A303 Amesbury to Berwick Down

Deadline 7
8.4(1) - Statement of Common Ground –
National Farmers Union

STATEMENT OF COMMON GROUND – National Farmers Union

Regulation Number:	Regulation 5(2)(q)
Planning Inspectorate Scheme Reference	TR010025
Application Document Reference	8.4(1)
Author:	A303 Amesbury to Berwick Down Project Team, Highways England and National Farmers Union

Drawing Title
**RIGHTS OF WAY AND ACCESS PLANS
REGULATION 5(2)(k) & 5(2)(o)
SHEET 4 OF 15**

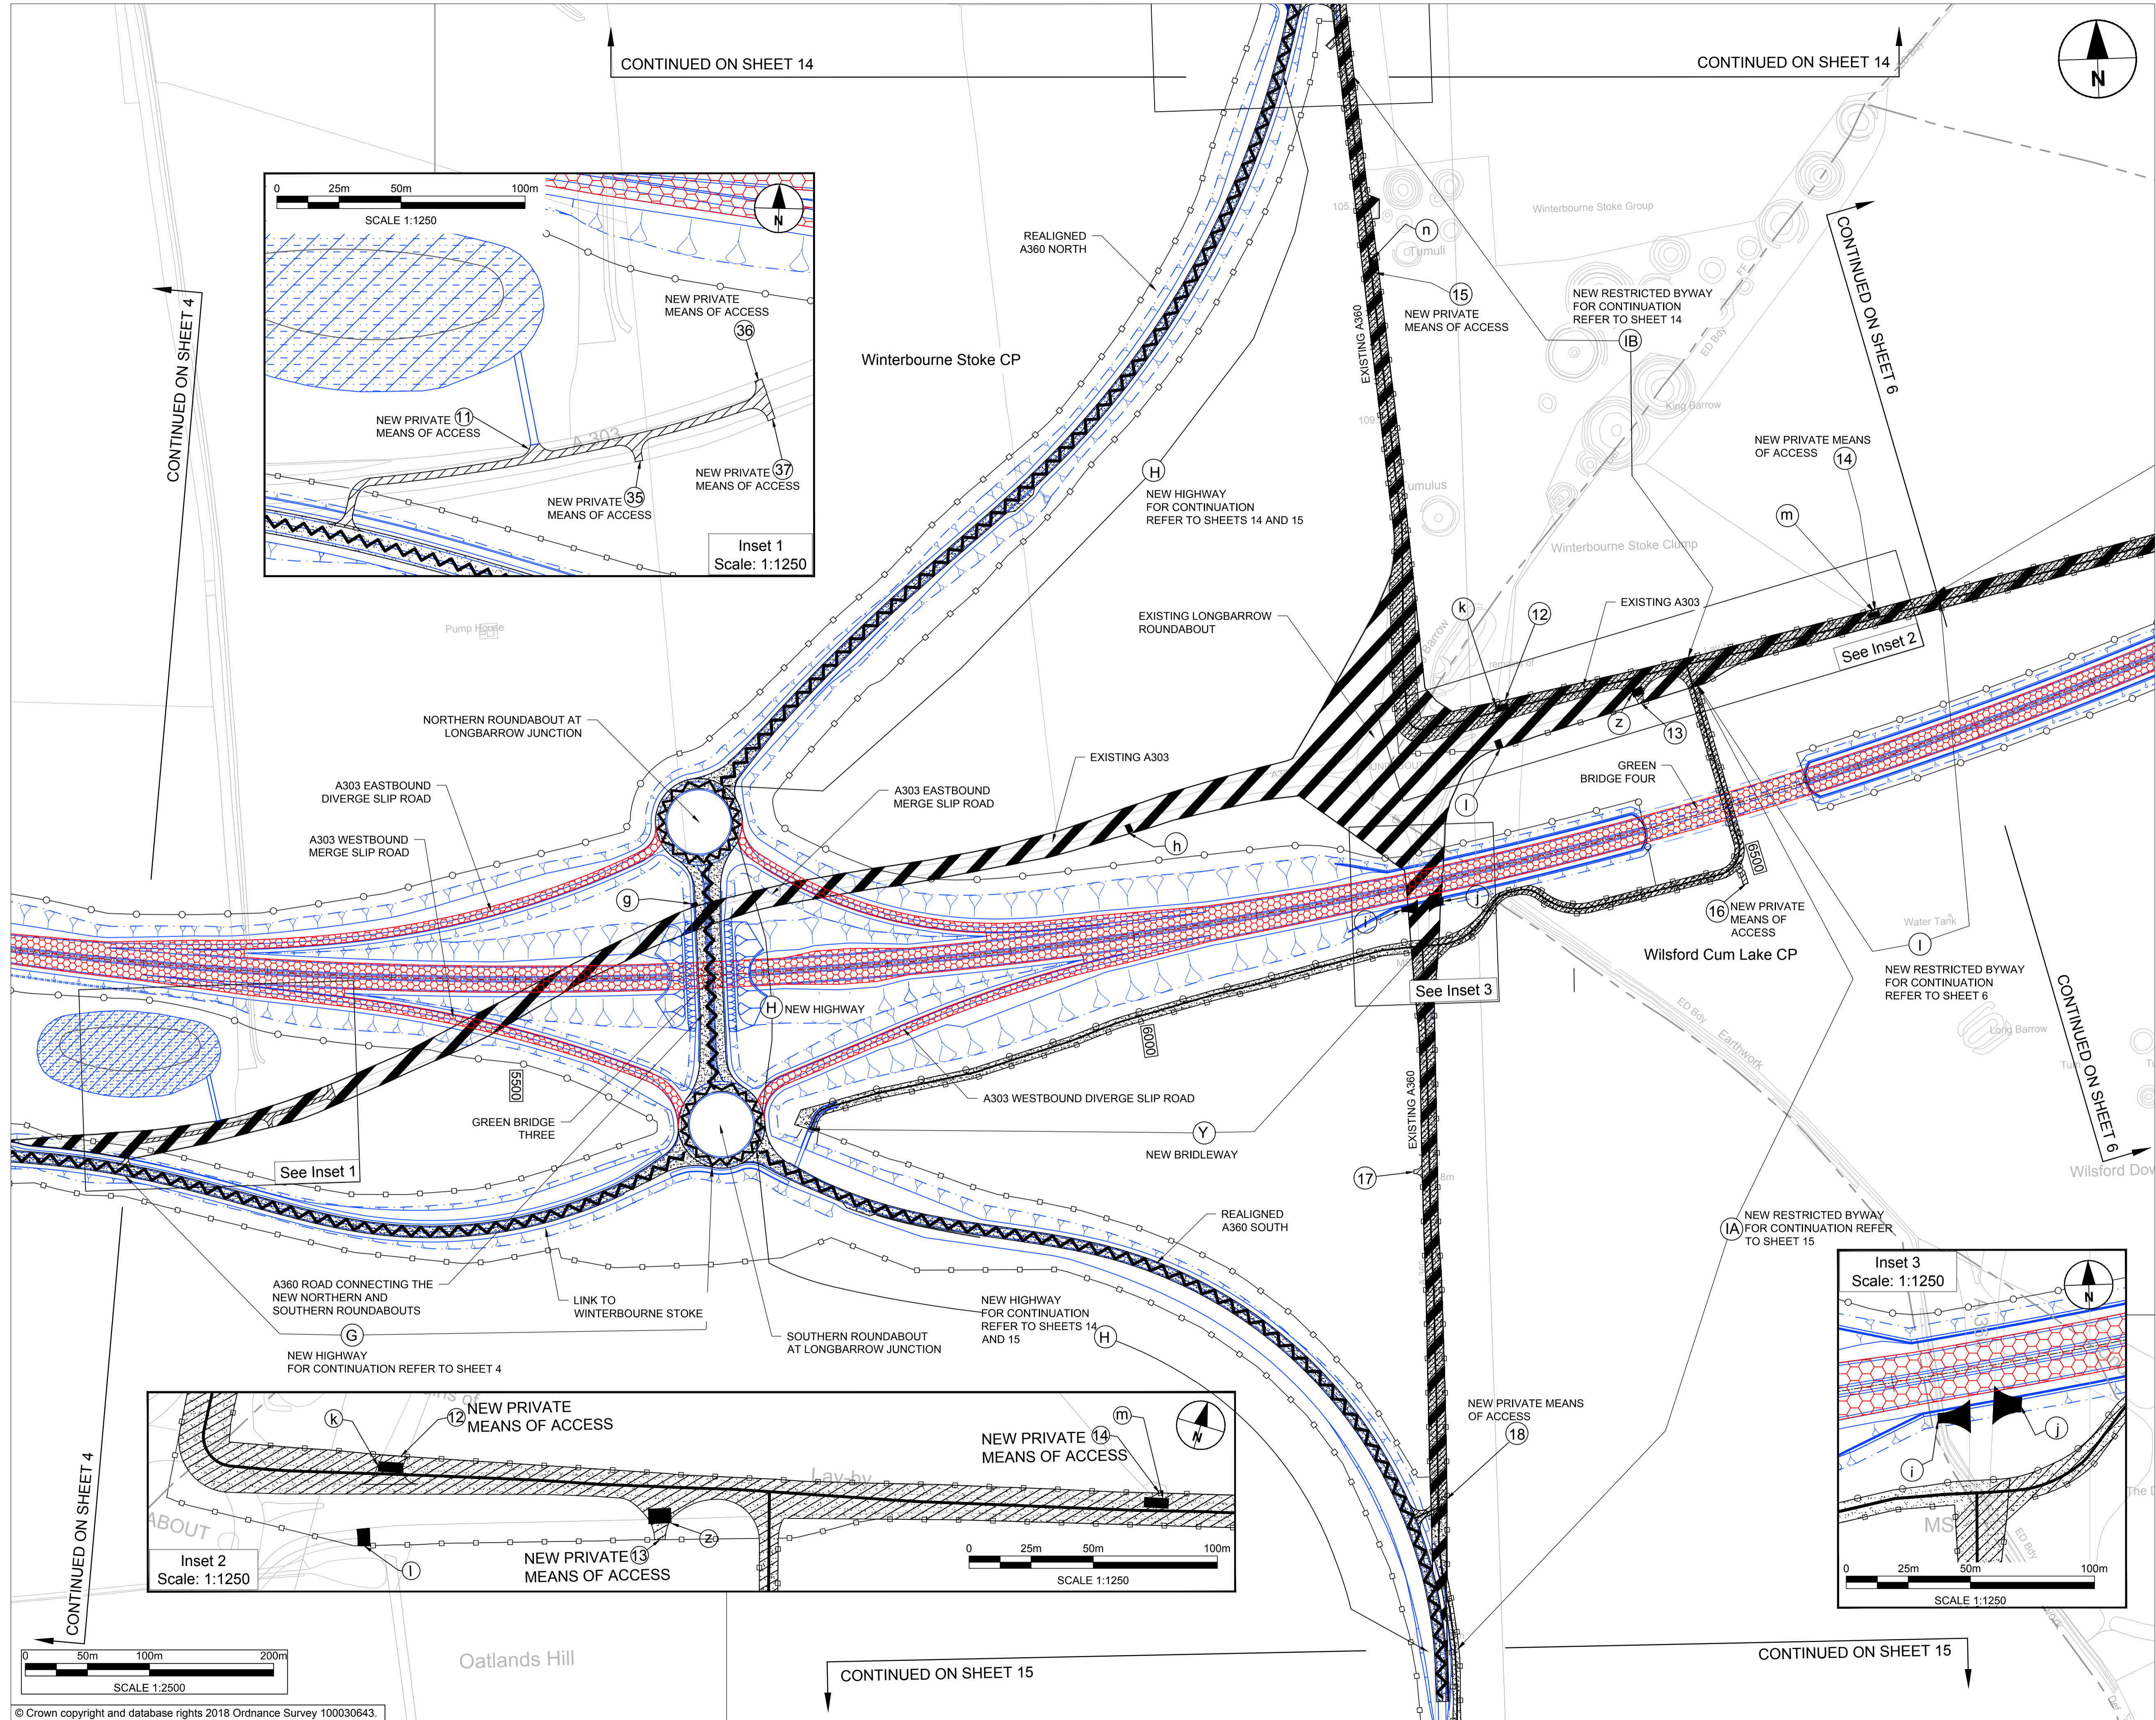
along the southern aspect of the River Till bridge.	
3.19	ES Chapter 11- Road drainage and the water environment [APP-049]	11.3 Assessment methodology (and Appendix 2.1)	11.3.10 – 11.3.13 Consultation	<p>Further information is needed in regard to the size and location of the drainage infiltration.</p> <p>Concern: The locations are greatly interfering with farm operations within fields.</p> <p>Solution: A new access route has been highlighted. This is not necessary and access could be created from the byway at green bridge no.2. (Turners)</p>	<p>Following this consultation feedback, the number of drainage infiltration areas has been rationalised in the application Scheme in terms of reducing the number from five to four and locating them closer to the new road. Due to the reduced number, each infiltration area needs to be slightly larger to meet the storage capacity requirement and to provide permanently wet areas to create dew ponds and allow for biodiversity enhancements. Access to the infiltration pond by Green Bridge 2 on the northern side of the A303 will now be accessed from the byway. Access to the pond on the southern side of the new road, by the viaduct, will be taken from a track within the field margin. The revised proposals can be seen within APP-009 2.6 Rights of way and access plans (sheet 4).</p>	AGREED
